BLANNING AMENDMENT

H09/0615/00

CHALET BUNGALOW AND
DETACHED GARAGE

Amendment: Alterations to dormer windows and eastern elevation, plus
details of materials

2939 - 001 B

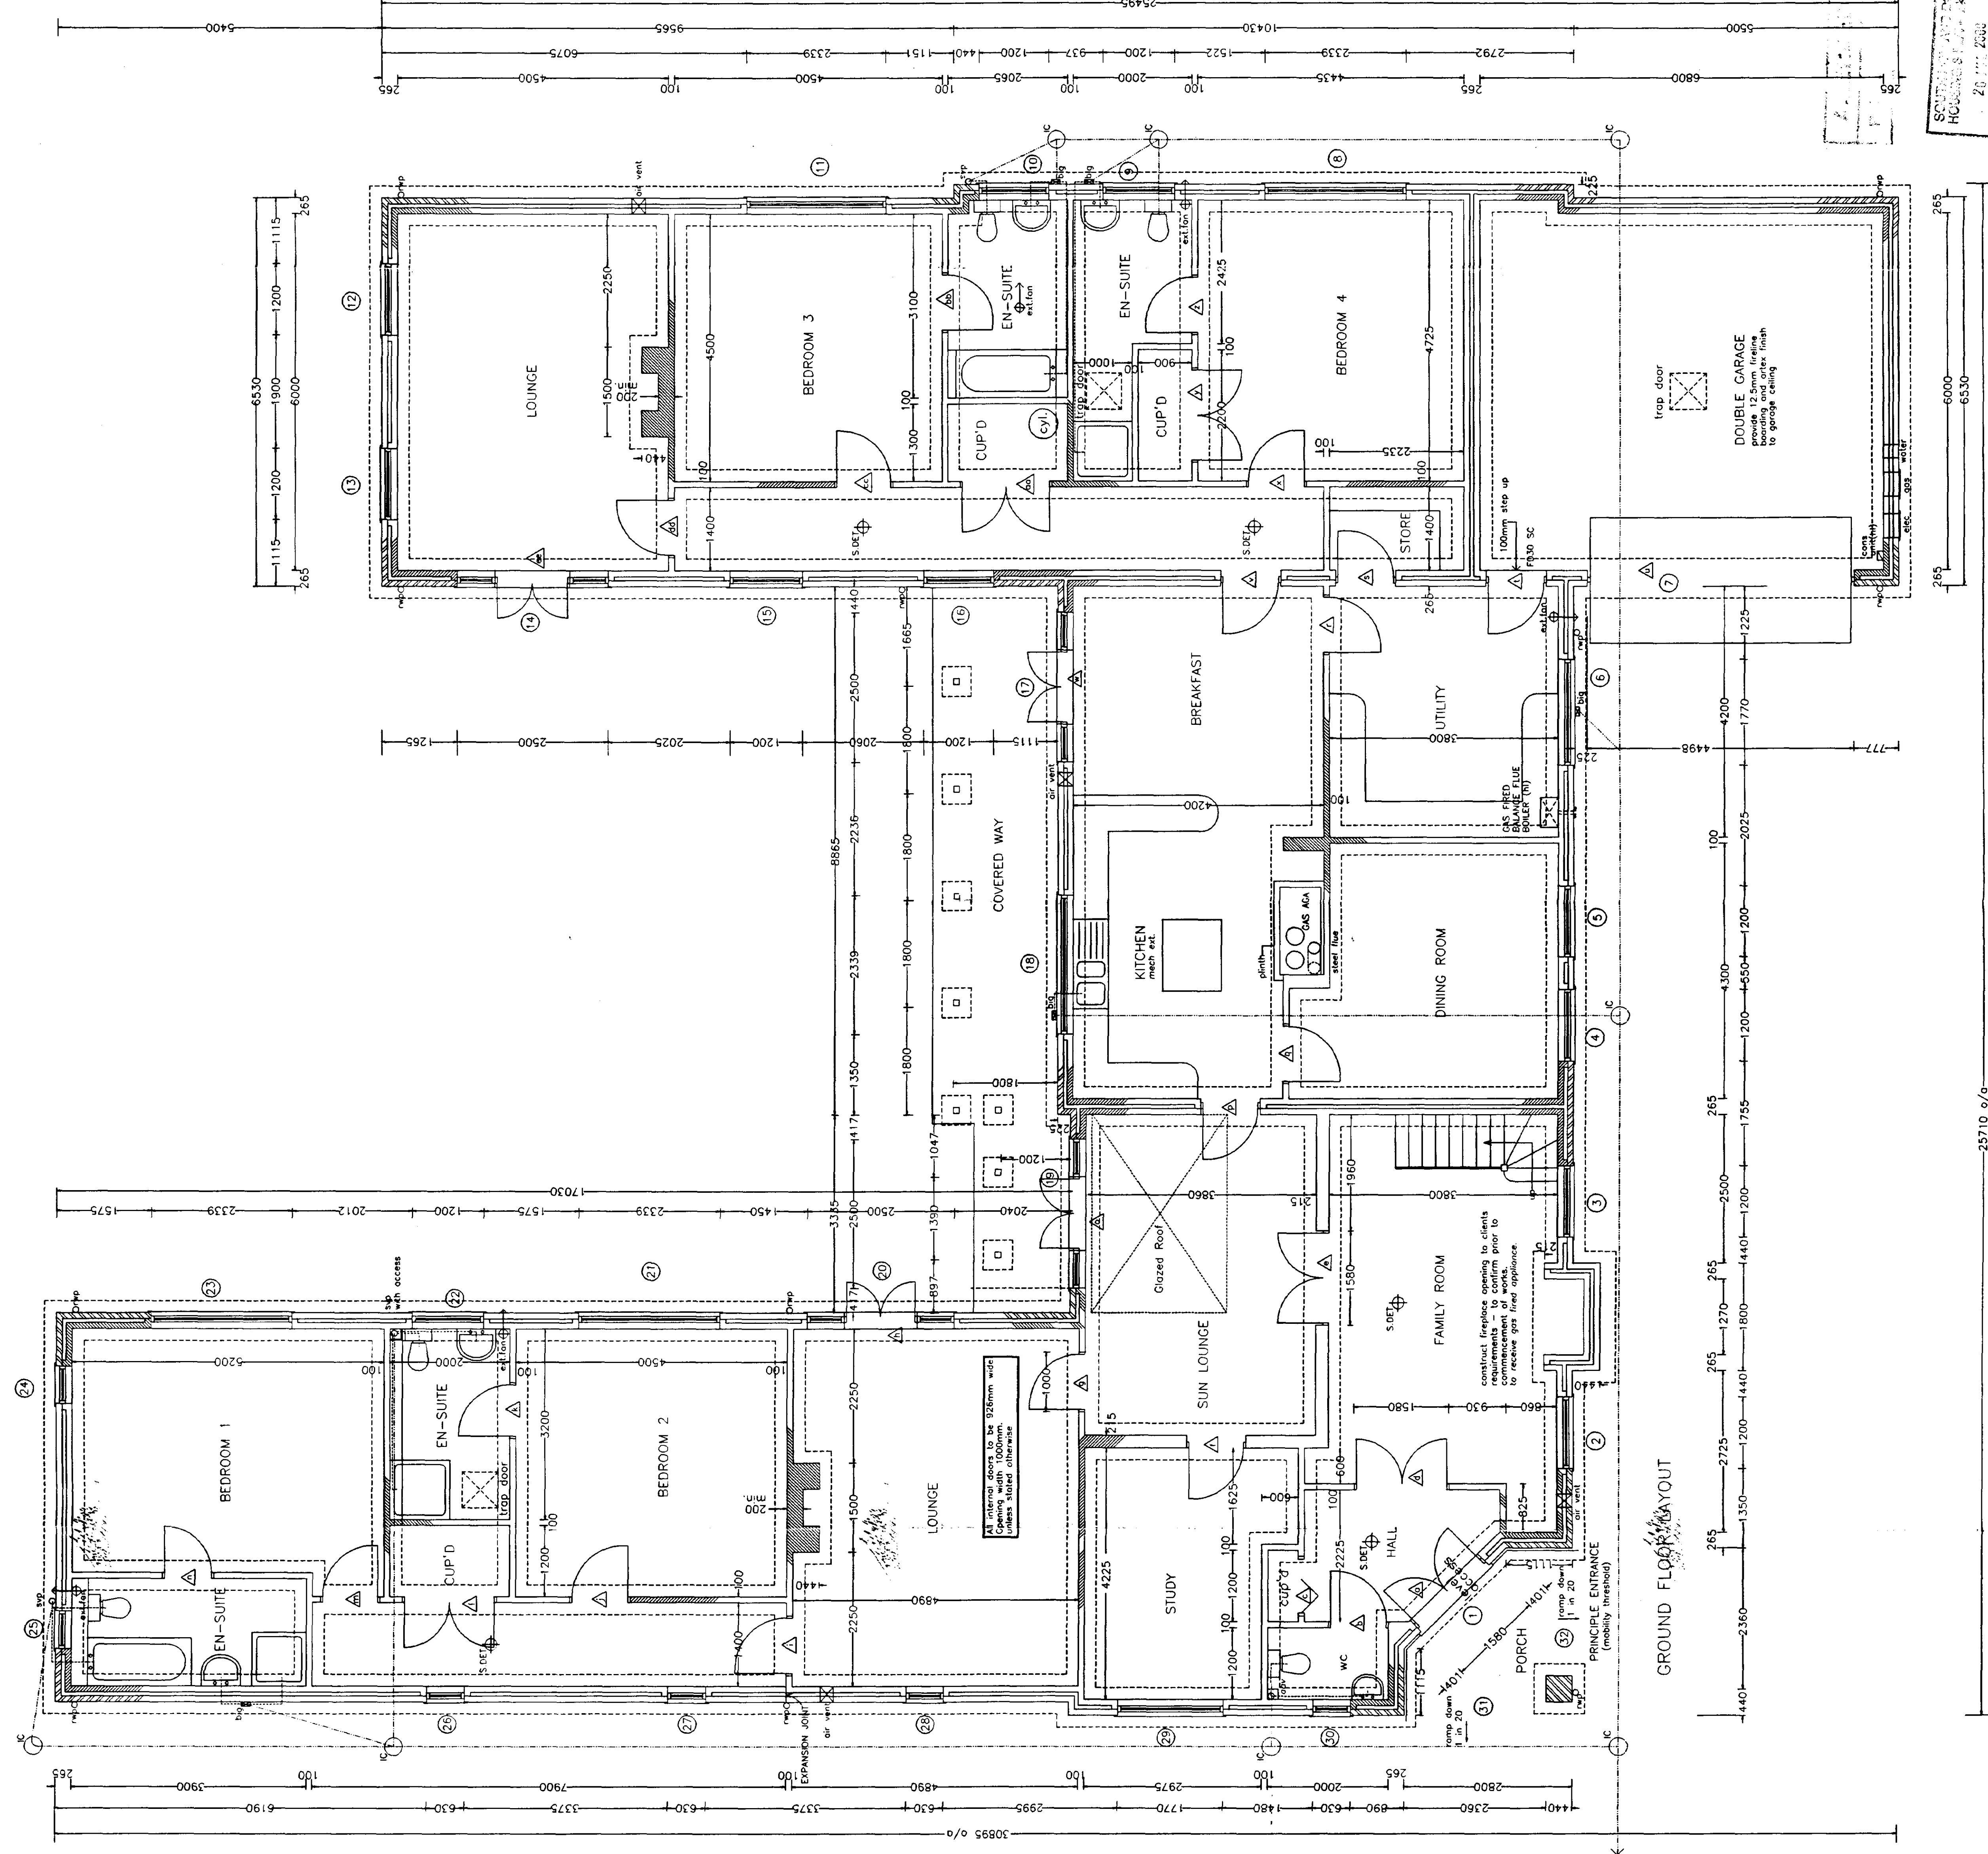
(A) 2 N^o PITCHED ROOF DORMER WINDOWS INTRODUCED IN LIEU OF CONTINUOUS FLAT ROOF DORMER, ON SOUTH ELEVATION
(B) GABLE END ON EAST ELEVATION EXTENDED OUT 225 MM
(C) VELUX ROOF LIGHT INTRODUCED ON NORTH ELEVATION
(D) EXTERNAL MATERIAL PROPOSALS SUBMITTED
FACE BLK: YORK HANDMADE OLD CAMP
ROOF TILES: CROMLEIGH WELSH BLUE SLATE BY HARRIS
2939-001 B + AMENDED ALL ELEVATIONS
STATE & VELUX
